Subject: RE: Planning Consultation on FP/42/19/DOC

Engineers Comments Regarding Condition 7

NB: Sub-base construction depths are shown as minimum construction requirements. Specific construction depths vary, e.g. where sub-base falls (to collection point) in opposite direction to surface falls. See respective Drainage Layout for specific sub-base levels.

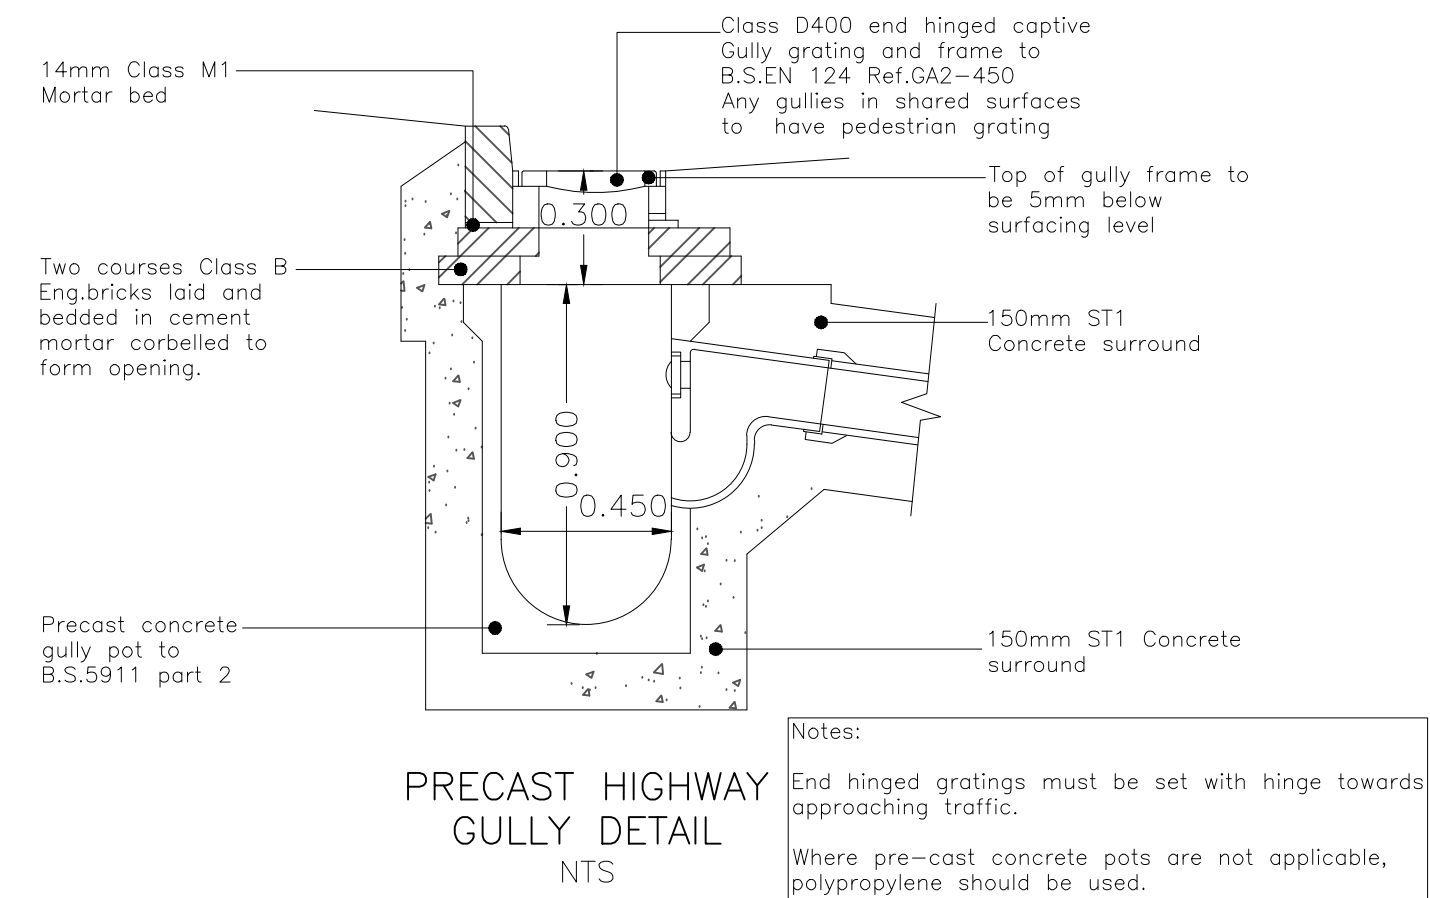
1. The construction detail drawings of the attenuation tanks needs to show the impermeable membrane around the tank, between the tank and the coarse sand bedding.
2. Can the catchpits please be labelled on plan.
3. 3m easement is not being provided to the watercourse at plots 12, 13 and 14. Please can this be provided. Or as a minimum demountable fences provided.
4. Please can the proposed landscaping plans be amended to remove the trees at the end of the parking area between plots 12 and 11/10? Trees are proposed directly in the location of the control chamber and in close proximity to the lined tank.

1. Catchpits must be provided upstream of all connections into the attenuation tank.
Please refer to drawing 5782:23 Construction Details demonstrating manhole SW04 and SW05 should be installed with 300mm deep catchpits.
